Our Ref: Y/122/20/NMA

Non material amendment following grant of Y/58/18/HH to move the front entrance back by 1m, build the structure using a highly insulated timber frame construction, and replace single roof lantern with 2 No. smaller panorooft low level skylights.

Carpenters Cottage Hoe Lane Flansham PO22 8NW

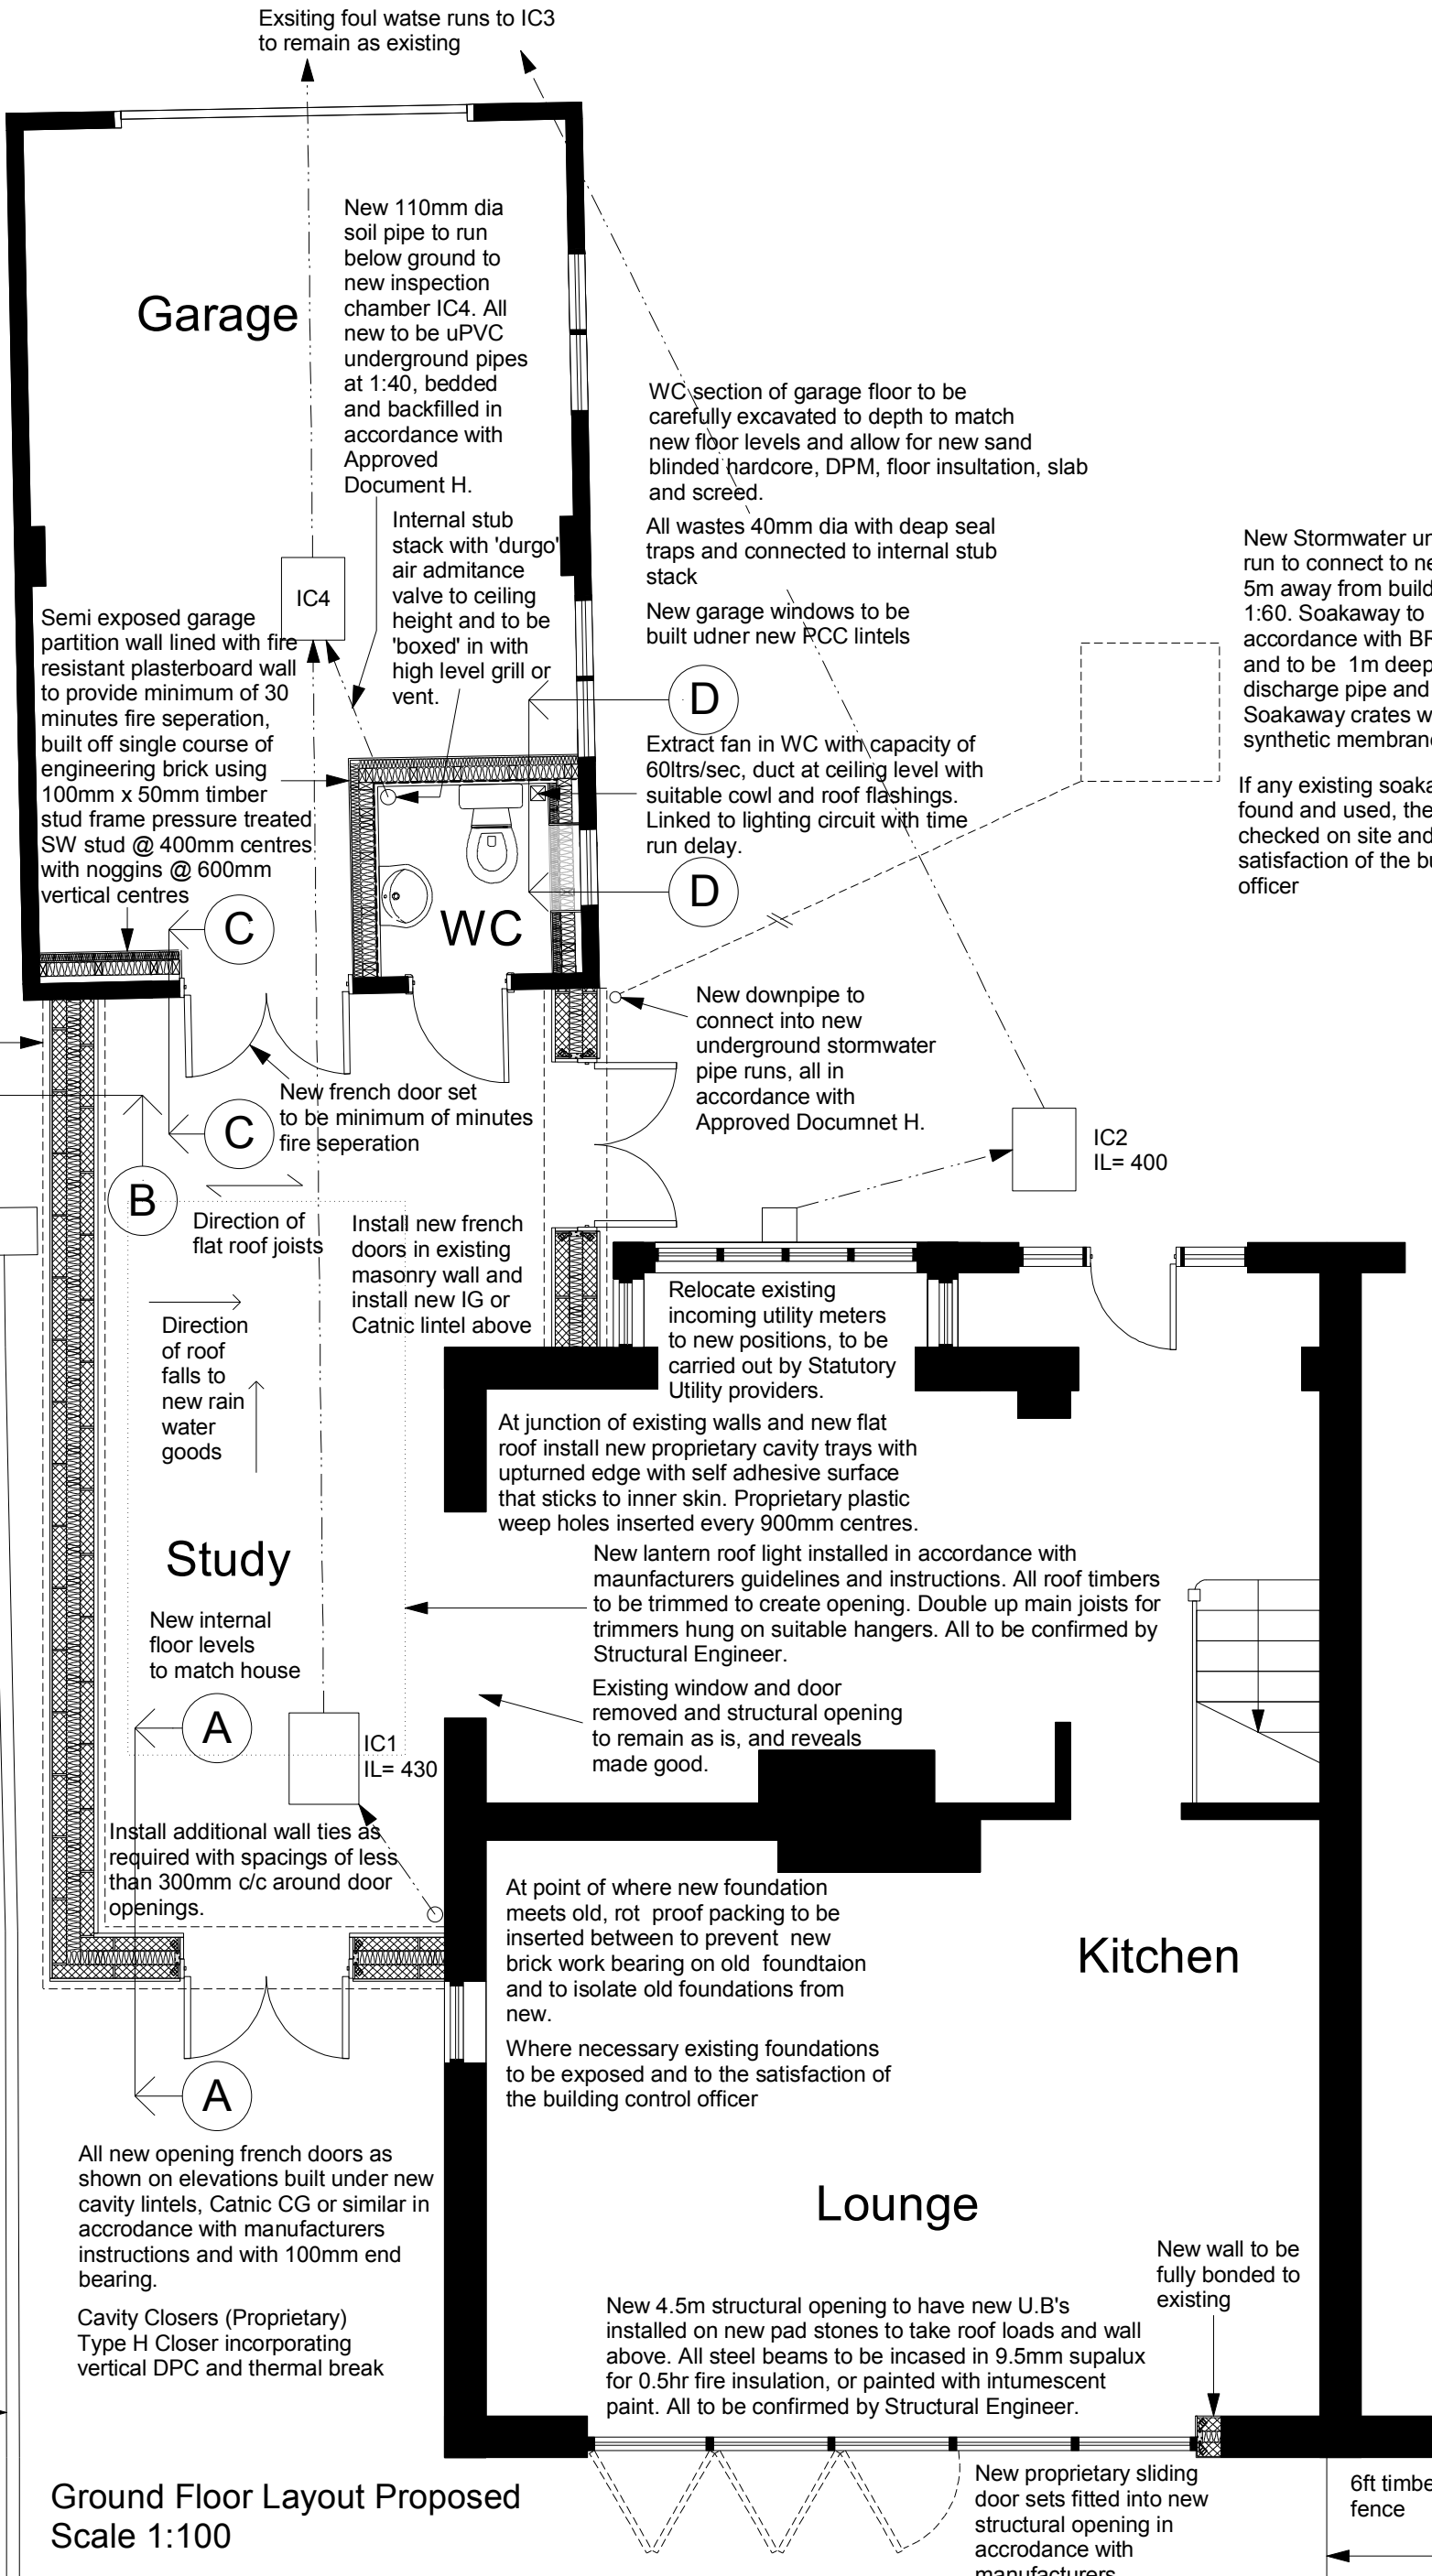
- Use a timber frame construction rather than brick/block.
- Move the front porch elevation west by 1m.
- Alter the rooflight from raised to flat.

From the information submitted I am able to accept drawing 'Proposed Floor and Roof Plan OM010 Rev B', 'Proposed Elevations' and 'Construction detail' as a Minor Amendment to Y/58/18/HH.
